Morgan and Morecambe Offshore Wind Farm: Transmission Assets

**Appendix H3 to Natural England's Deadline 3 Submission
Natural England's comments on Onshore and Intertidal Ornithology**

Planning Inspectorate Reference EN020028

15 July 2025

Figure 1 : Indicative Cross Section of the River Ribble Crossing (refer to the Onshore Works Plans (APP-154))

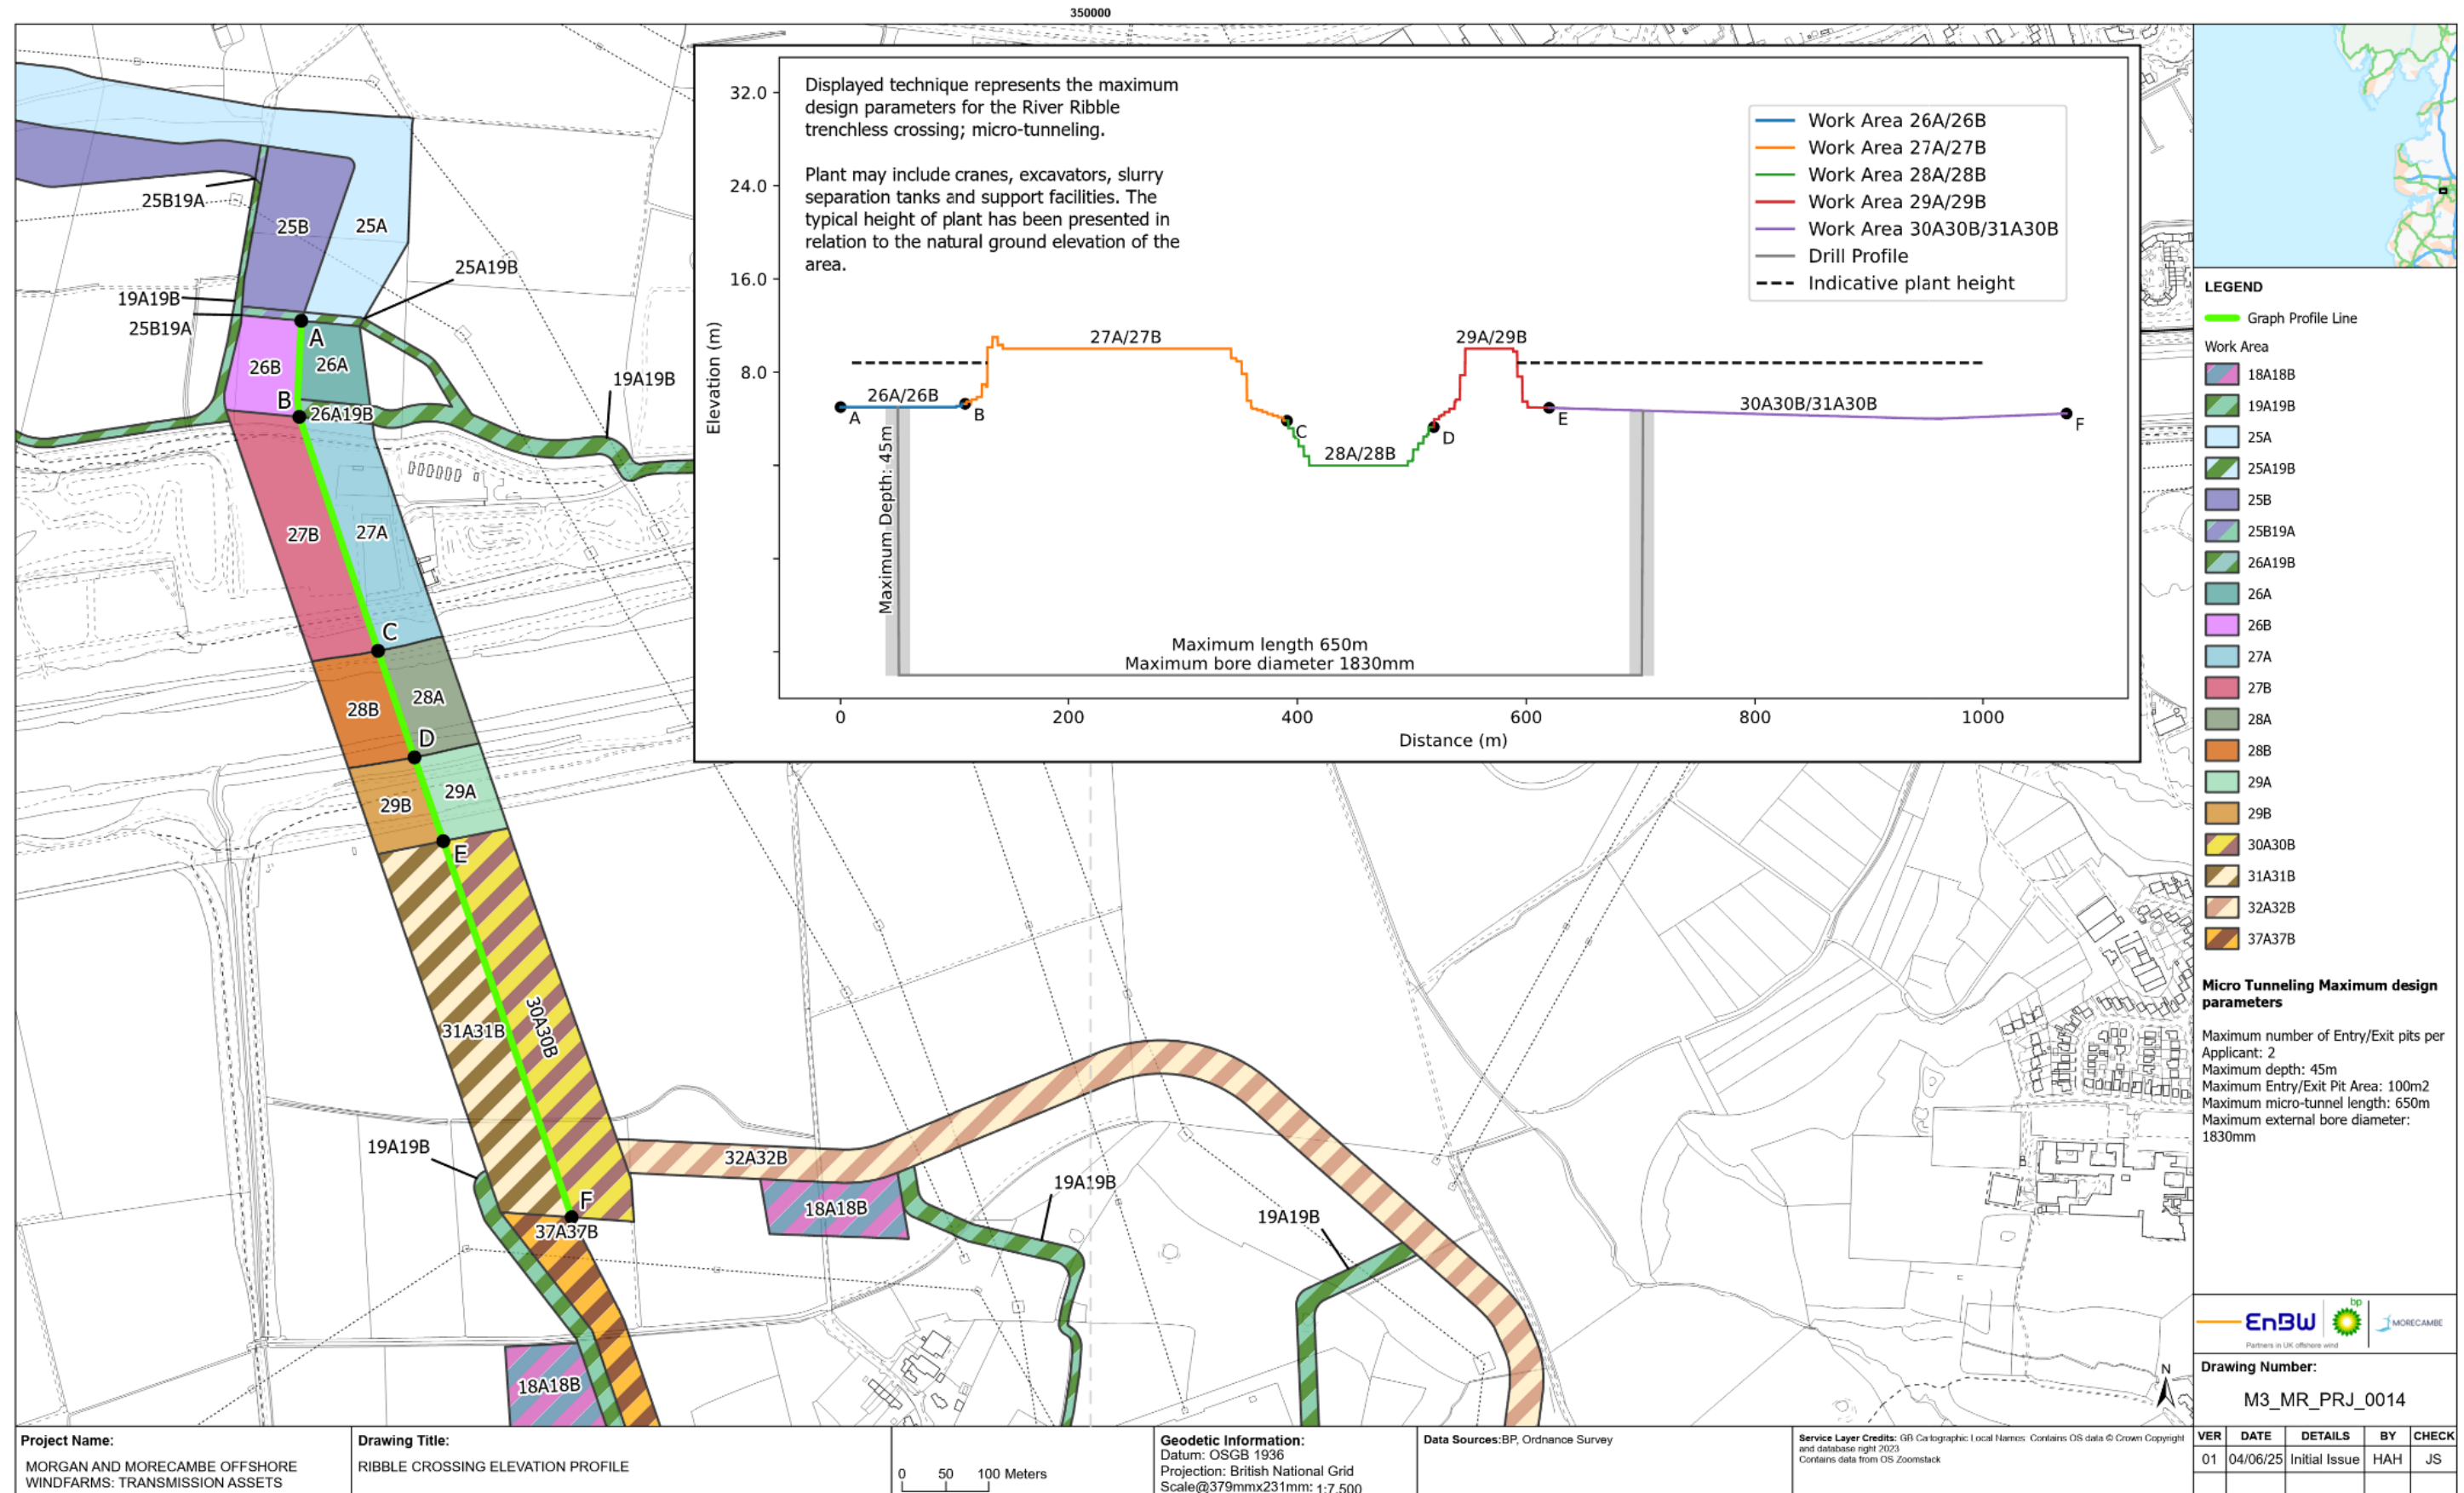
The information provided in [REP2-044] satisfies Natural England's concerns relating to potential visual impacts and noise impacts on ornithological receptors present at the River Ribble Crossing. The technical note contains sufficient additional detail on the extent of the flood embankments, the presence of hedges and the steep slope down to the farmland (where the entry and exit pits will be located, sitting below the embankment height). Taken together, this information illustrates that visual disturbance impacts to SPA/Ramsar site waterbirds are unlikely to occur. Further, due to the presence of the embankments, the noise modelling presented in [REP2-044] shows noise levels will be below the level where disturbance is likely to occur.

We believe this issue can be readily resolved if the Applicant includes appropriate text to reflect this additional detail in the ISAA document [APP-017]. This is also stated in our Risk and Issues Log (Appendix K, comment ref: RI_H27).

**Figure 6: Proposed Construction Works in relation to Newton Marsh SSSI**

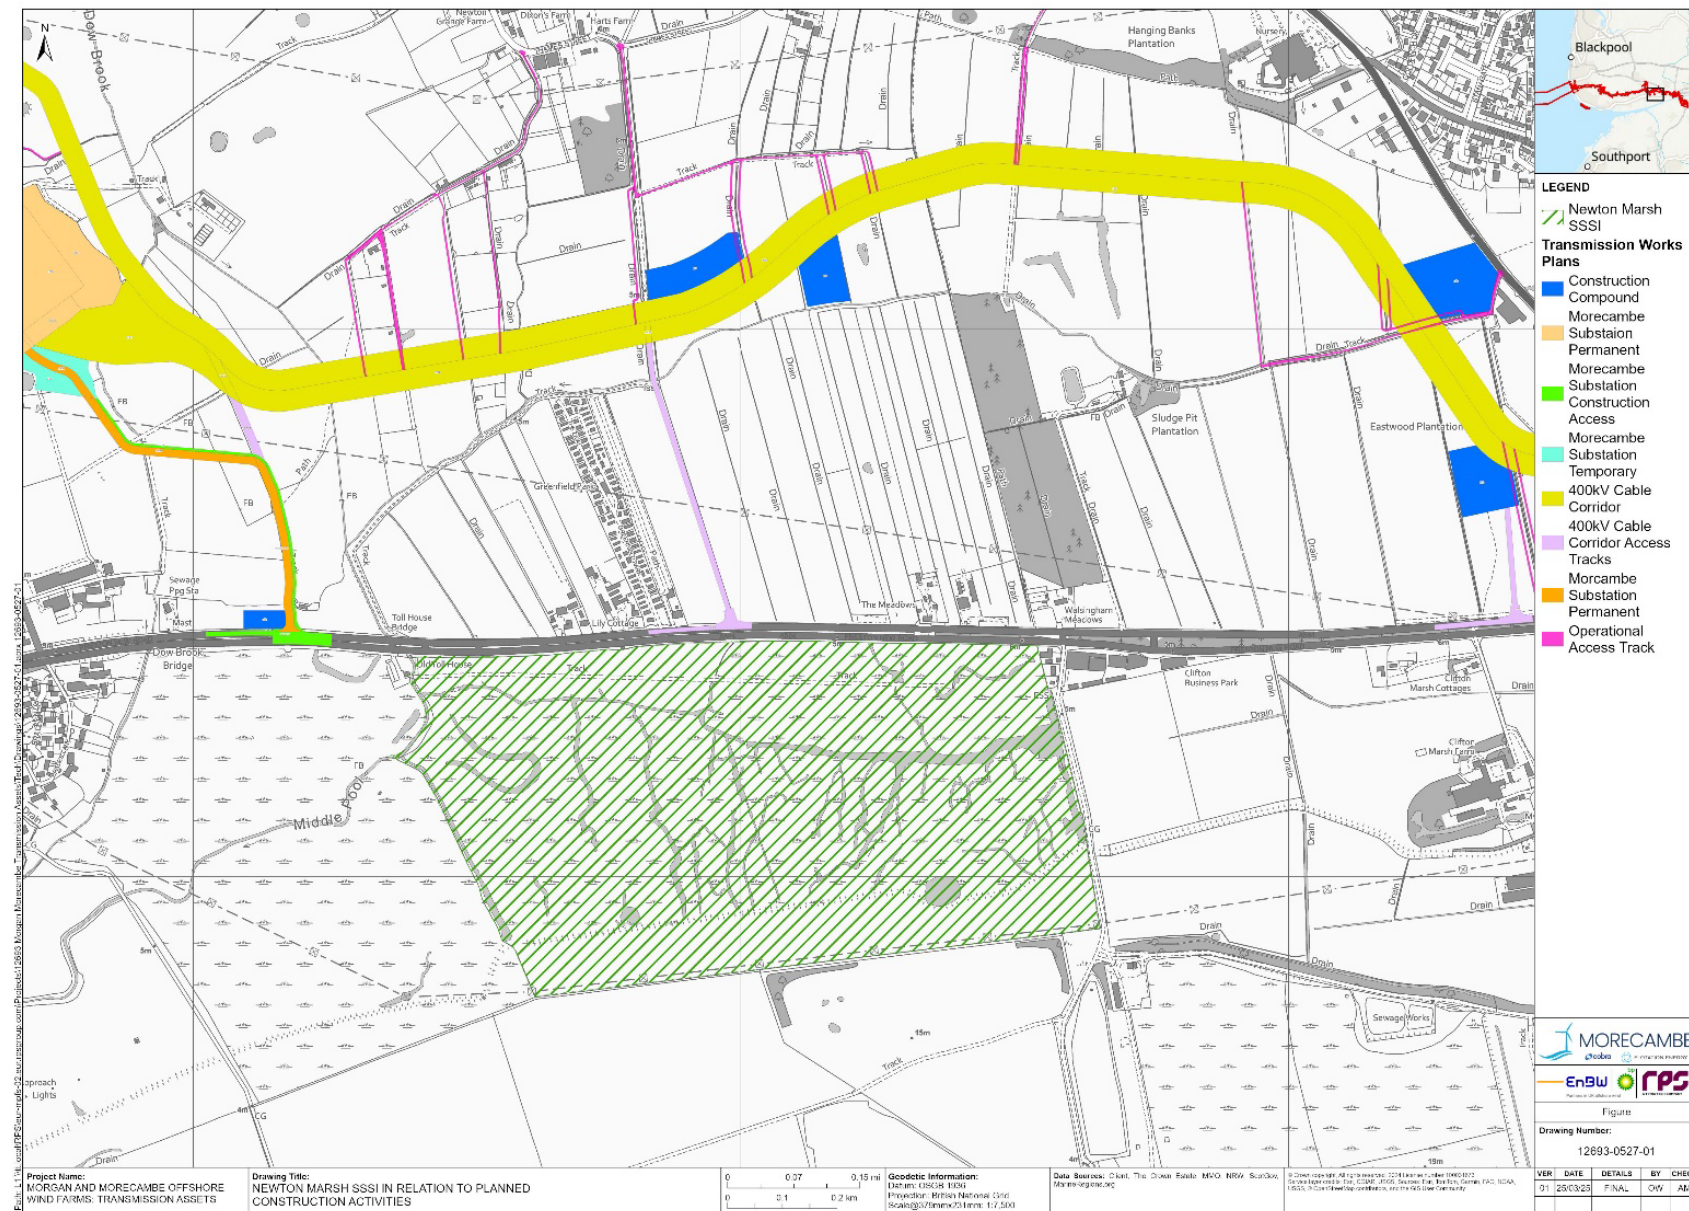
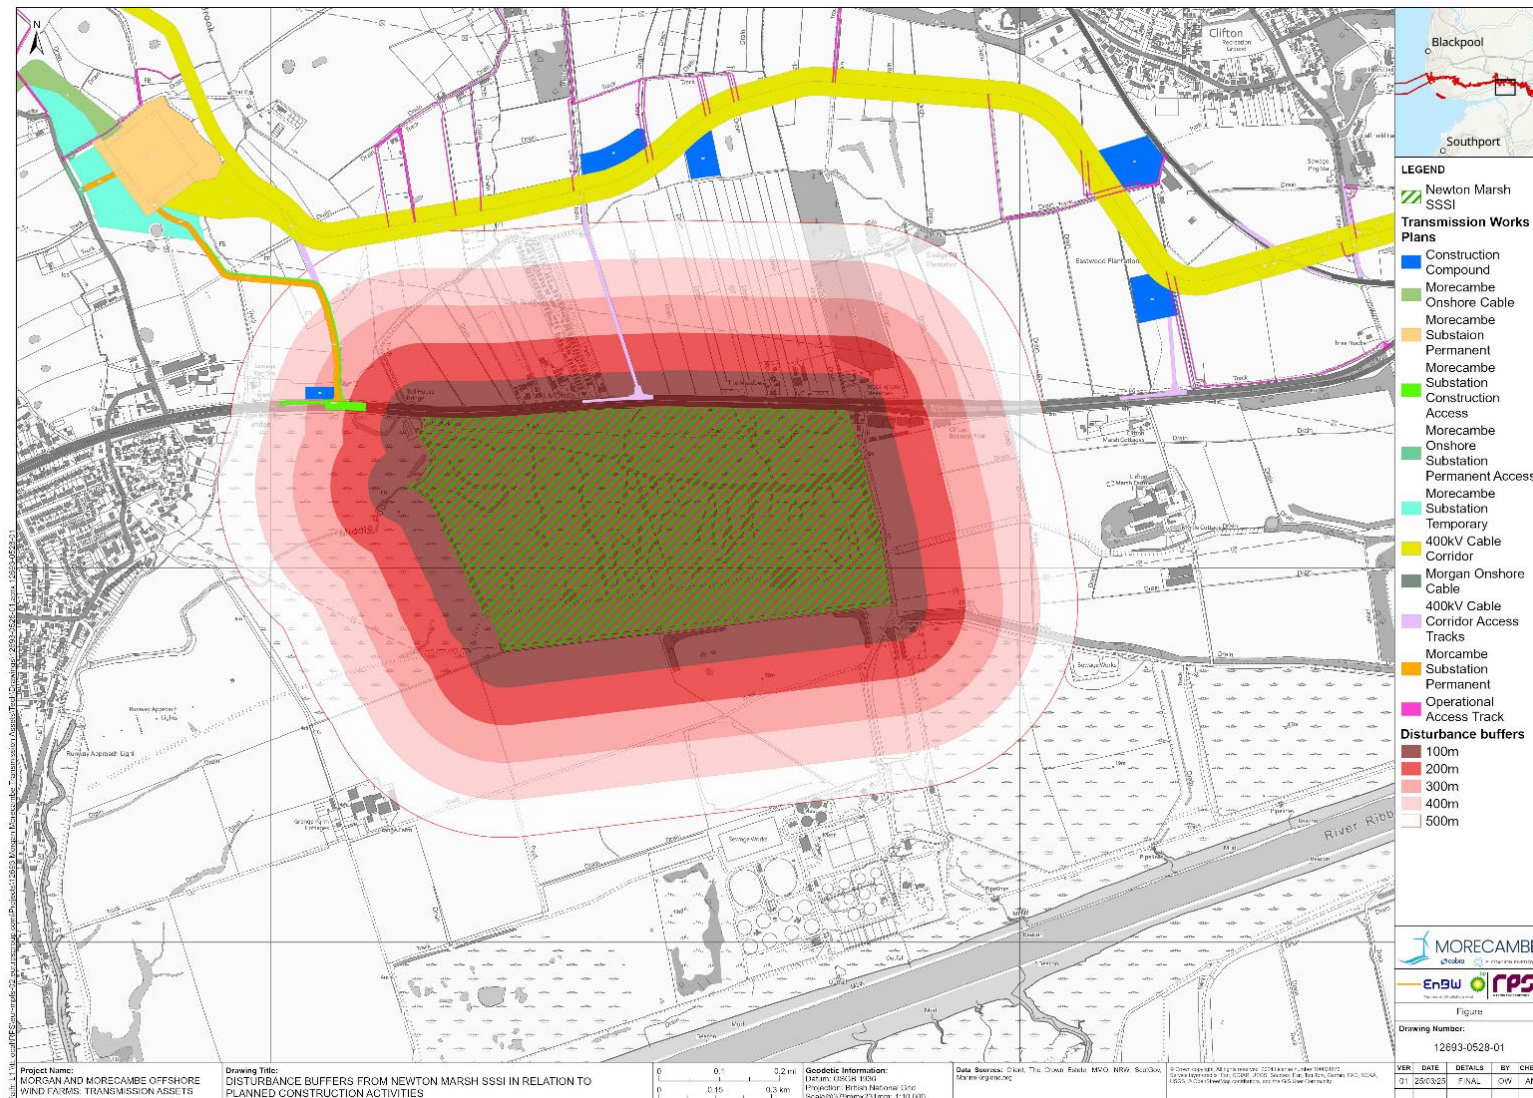
Natural England welcome the Applicant’s provision of the Technical Note on Newton Marsh SSSI and River Ribble Crossing [REP2-044]. The information provided in [REP2-044] satisfies

Natural England's concerns relating potential to impacts on Newton Marsh SSSI from visual and noise disturbance. The technical note contains sufficient detail on the trenching and cable burial activities, construction compounds and access tracks in close proximity to the SSSI.

We believe this issue can be readily resolved if the Applicant includes appropriate text to reflect this additional detail in the Information to Support an Appropriate Assessment (ISAA) document [APP-017]. This is necessary as the site is used by SPA/Ramsar site waterbirds, and therefore the issue is an SPA/Ramsar site as well as an SSSI matter. This is also stated in our Risk and Issues Log (Appendix K, comment ref: RI_H8).

Should any design changes/ changes to construction parameters occur which may affect the potential for disturbance on the SSSI, Natural England should be informed.
